Application for Removal or Variation of a Condition following Grant of Planning Permission or Listed Building Consent

Erection of a two storey rear extension and a single storey rear and side extension. at 58 Woodfield Drive, Winchester, SO22 5PU

21/02461/HOU

Condition 2

SCALE	DATE	AUTHOR	CHK'D
1:50 @ A1	May 22	CA	
JOB NO.	DRAWING NO.	REV	
1006	200	T3

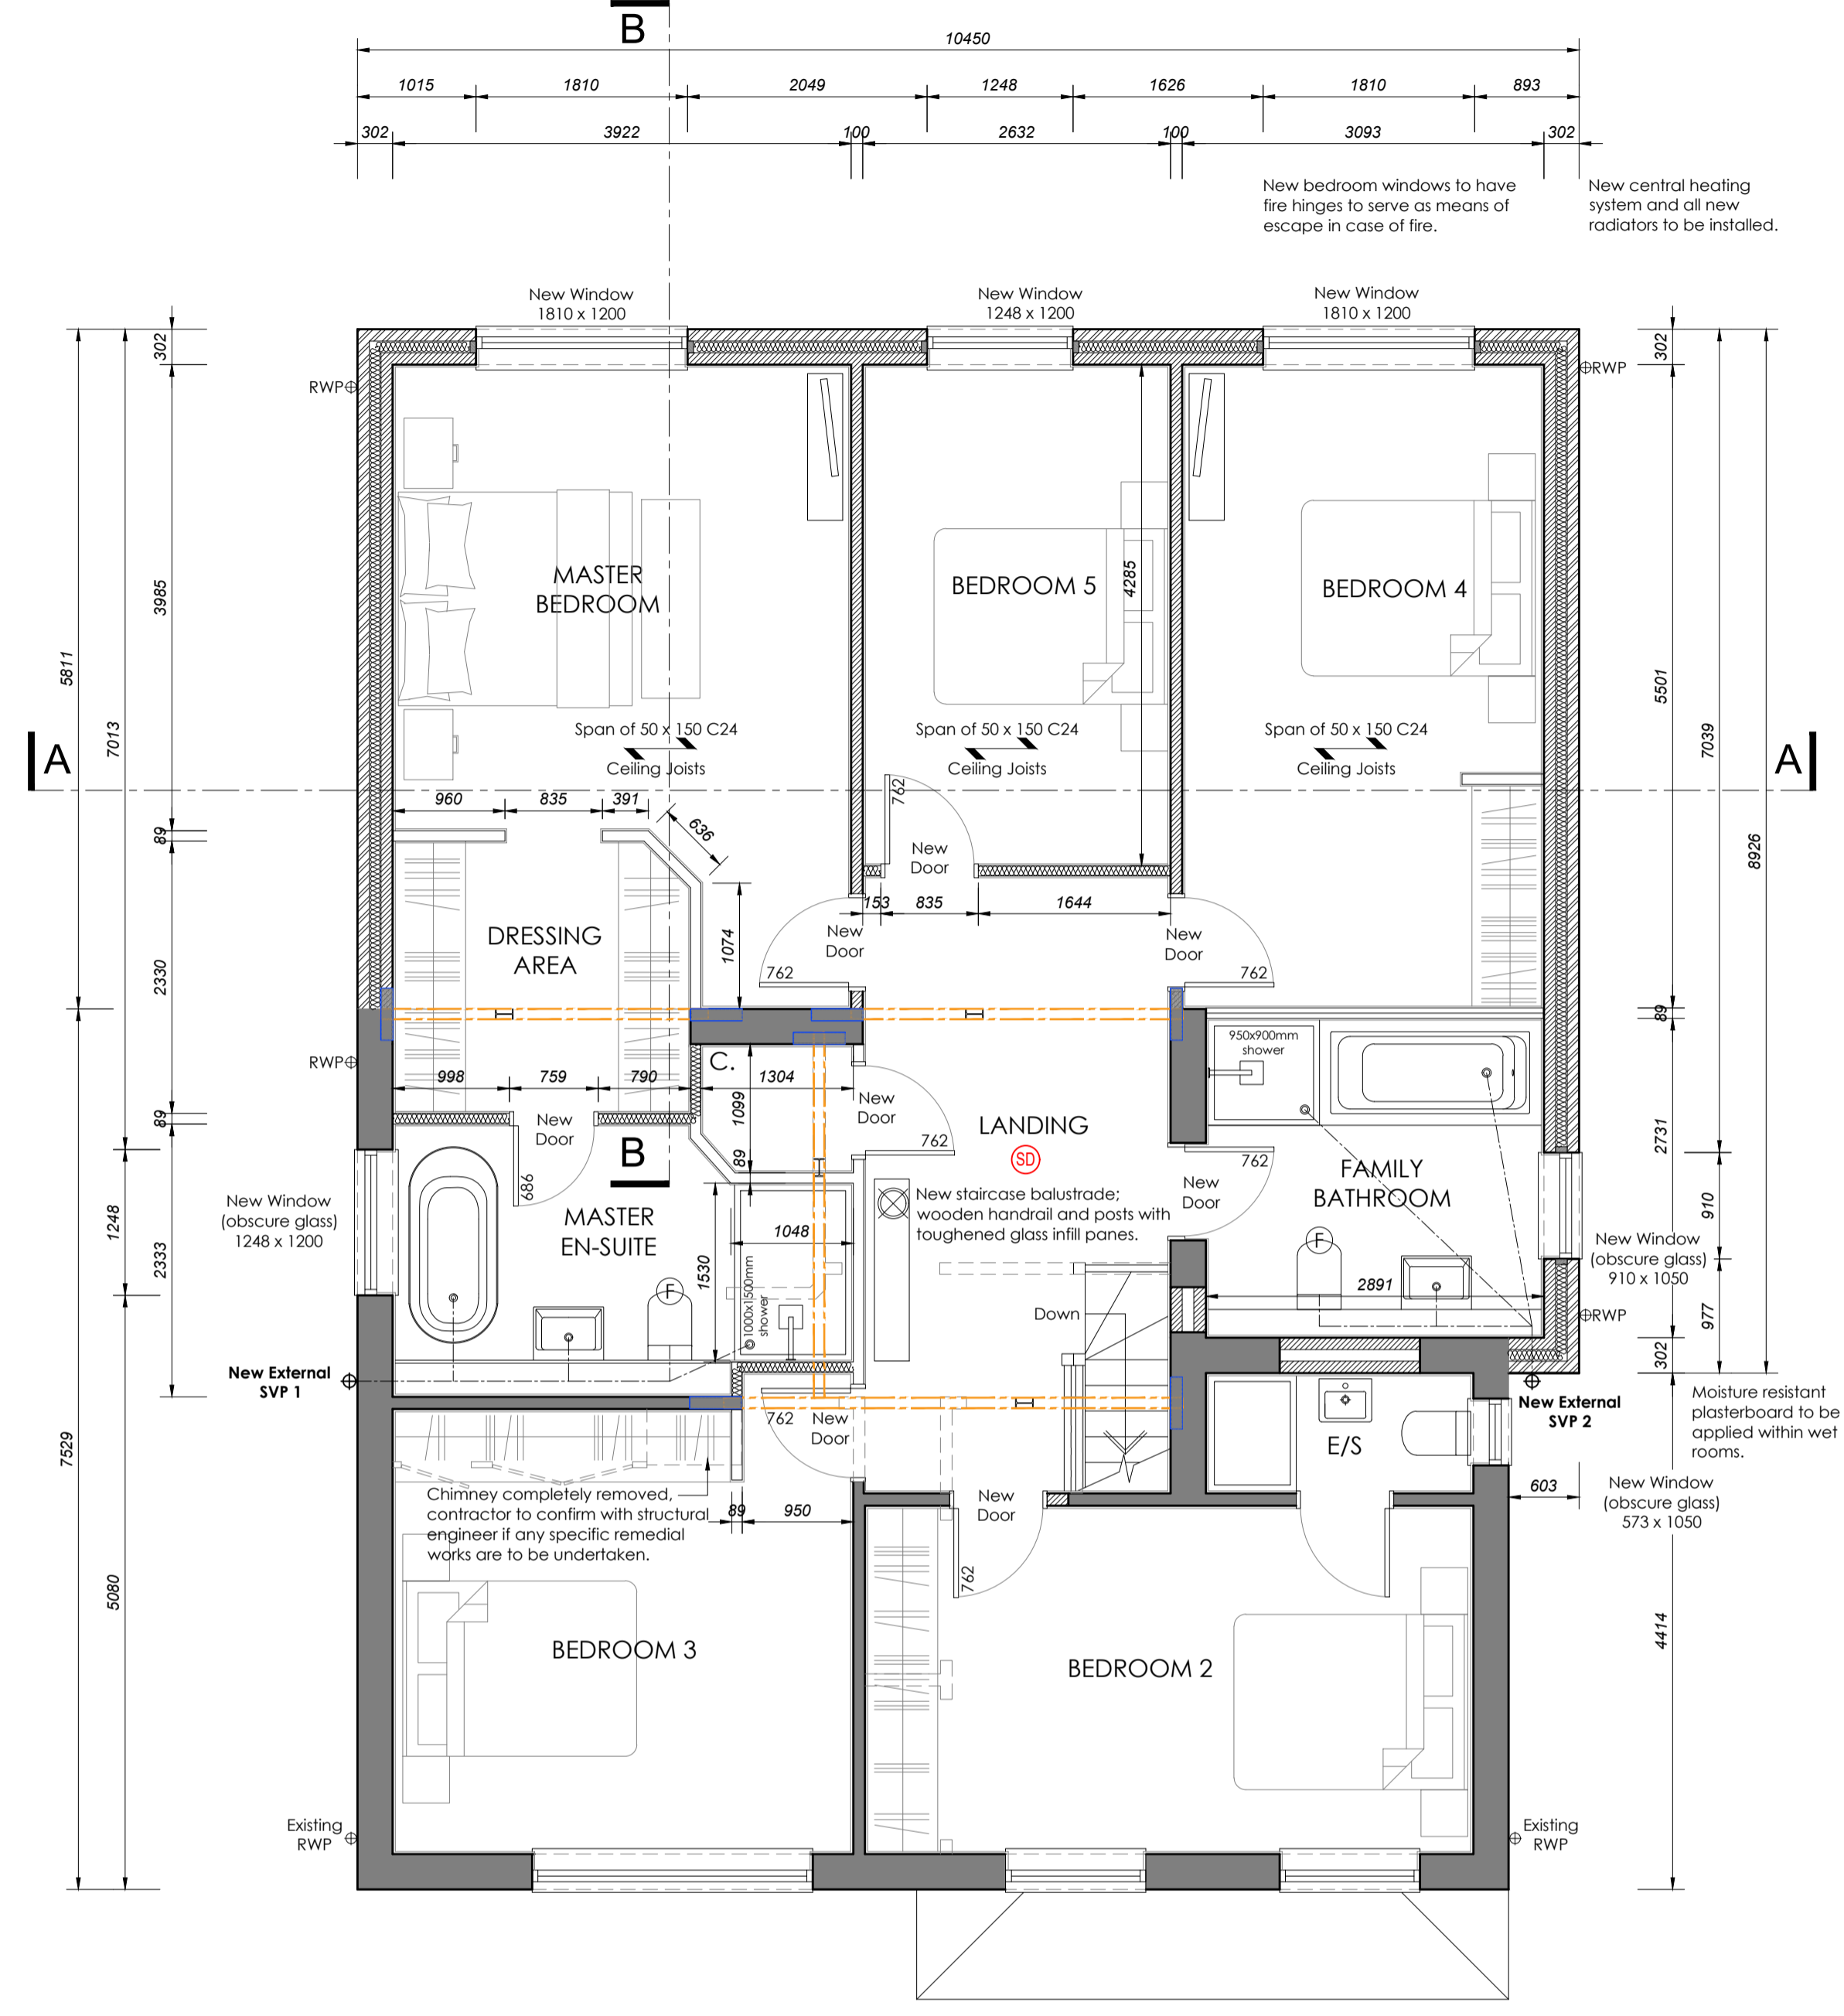
For financial reasons we have undertaken a value engineering exercise. The conclusion of this this exercise has been to reduce the footprint of the extension by removing the single storey side extension and also retaining as much of the existing roof as possible. The previous scheme removed the entire existing roof and replaced with new, however, a quicker and more constructible way has been established to tie the new extension area into the existing roof structure.

- 1006-100 T3 SUBSTRUCTURE AND ROOF PLANS
- 1006-200 T3 GROUND AND FIRST FLOOR PLANS
- 1006-400 T3 ELEVATIONS
